From: James Hutchison [REDACTED]
Sent: 26 July 2019 10:45
To: Simon Davis <Simon.Davis@arun.gov.uk>
Subject: RE: Y/32/19/RES - Land Adj Lake Barn. Maypole Lane, Yapton

Drawing title Proposed Floor Plans

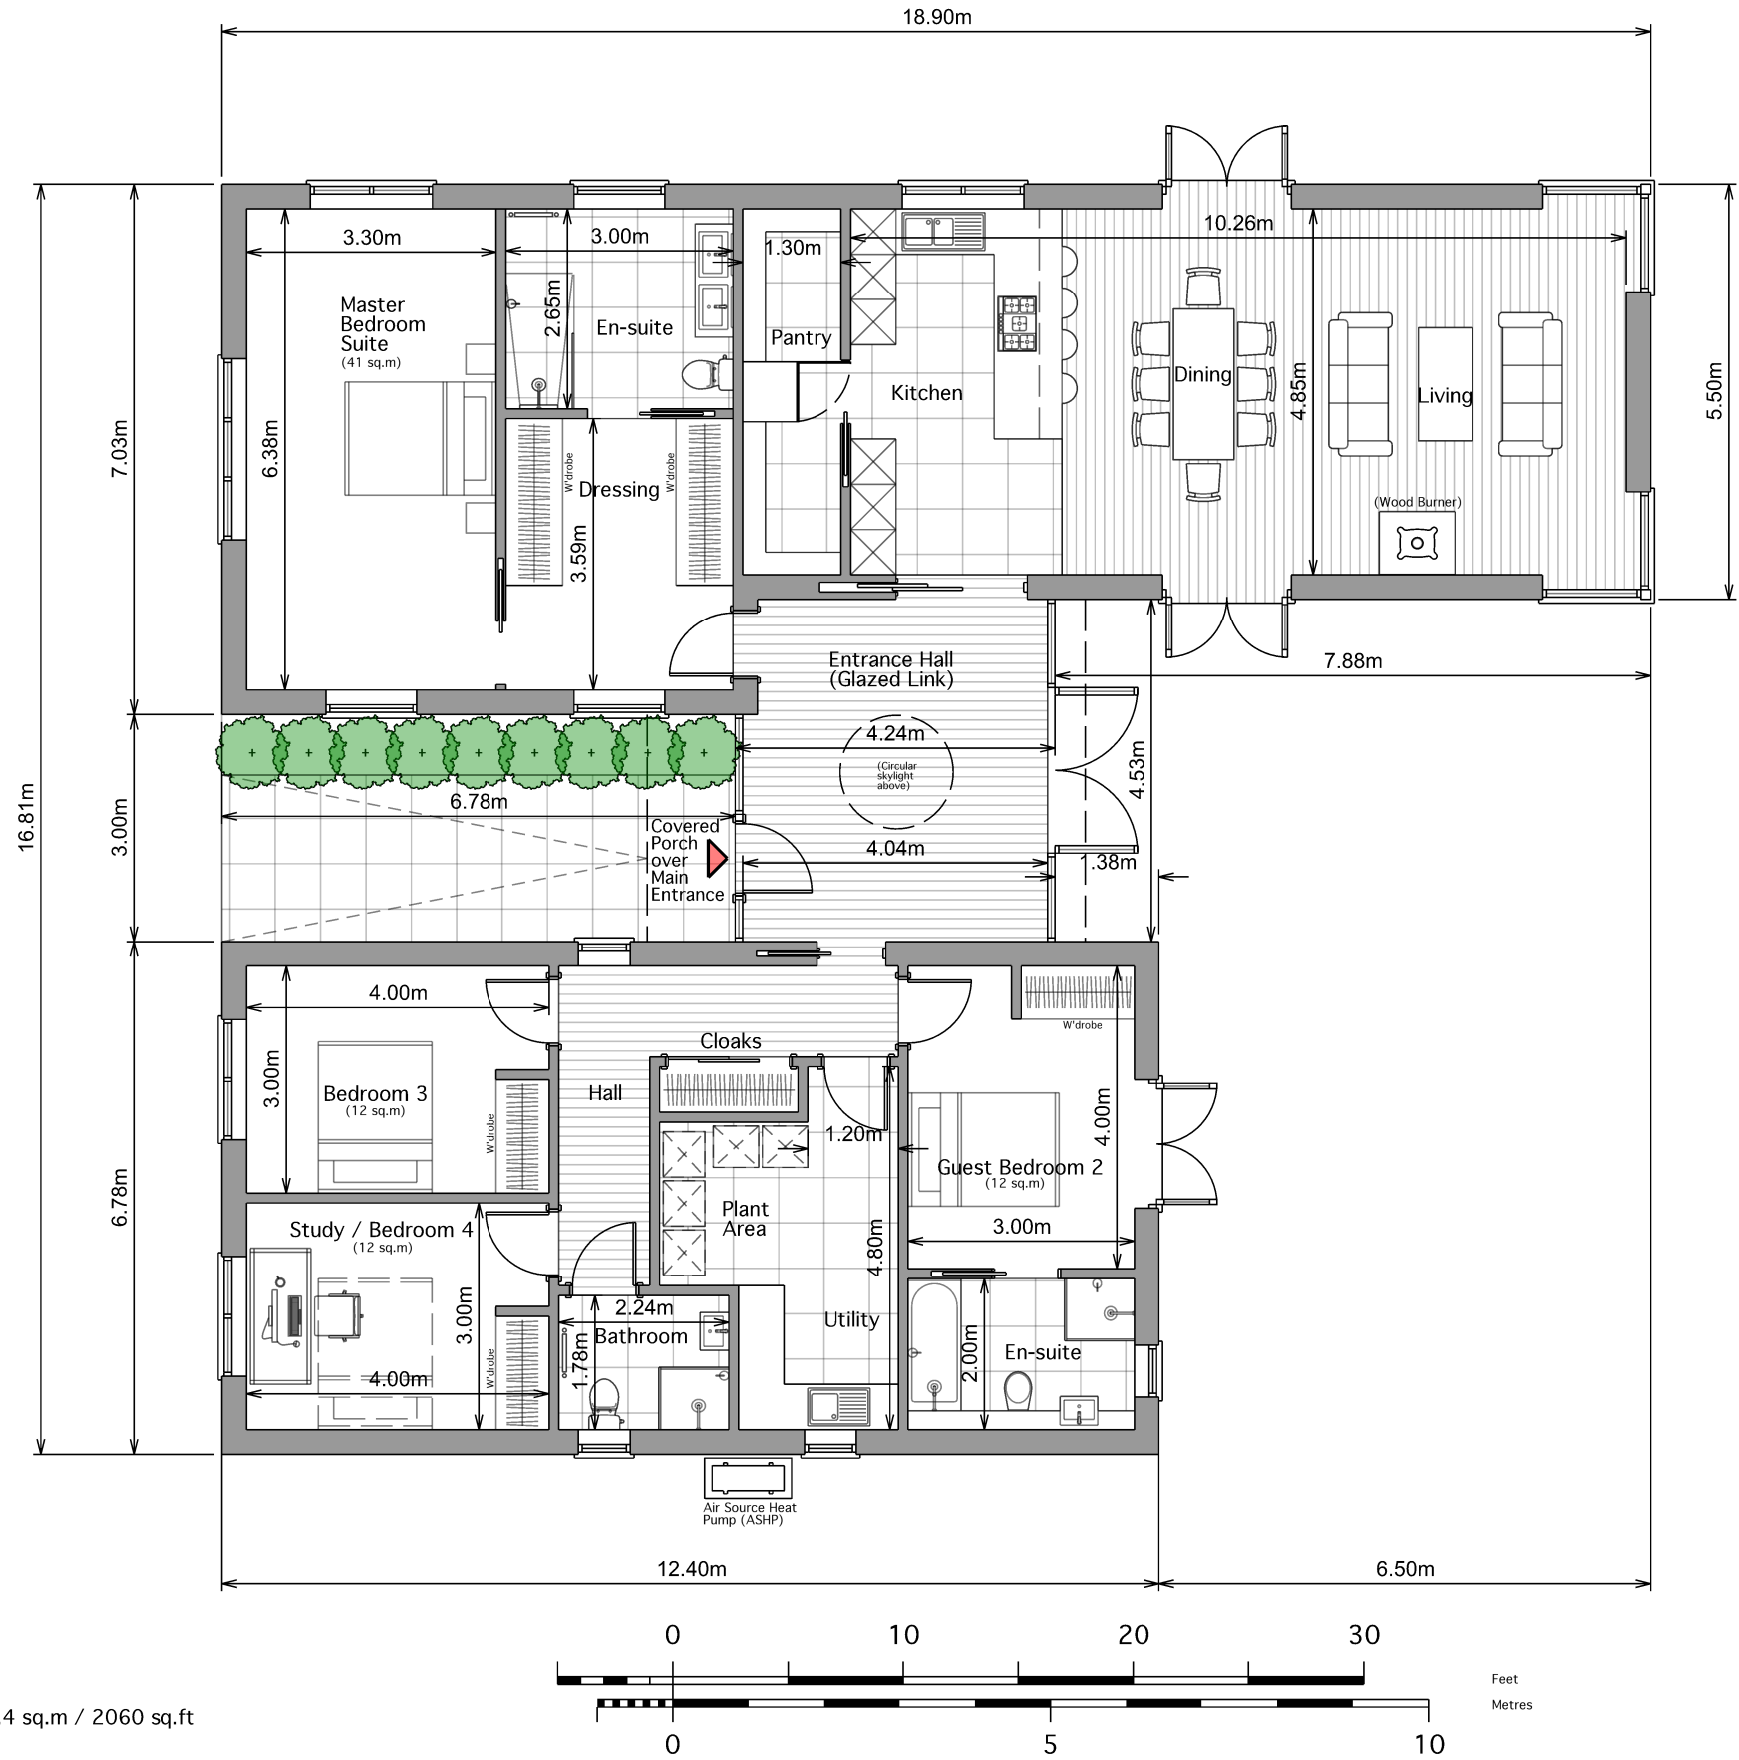
3. I will ask the architect to confirm this detail (car charging points) in a non-material revision to the floor plan.

Please note that a condition will be imposed requiring a strategy for the provision of electric charging facilities. Our standard condition is as follows: *Prior to occupation of the new dwellings, a strategy for the provision of facilities to enable the charging of electric vehicles to serve the approved dwellings shall be submitted to the local planning authority for approval and thereafter implemented in accordance with the approved details and the charge points shall thereafter be permanently retained and maintained in good working condition. Reason: New petrol and diesel cars/vans will not be sold beyond 2040, and to mitigate against any potential adverse impact of the development on local air quality, in accordance with policy QE DM3 (c) of the Arun Local Plan, the Arun District Council Electric Vehicle Infrastructure Study (November 2017) and the National Planning Policy Framework.*
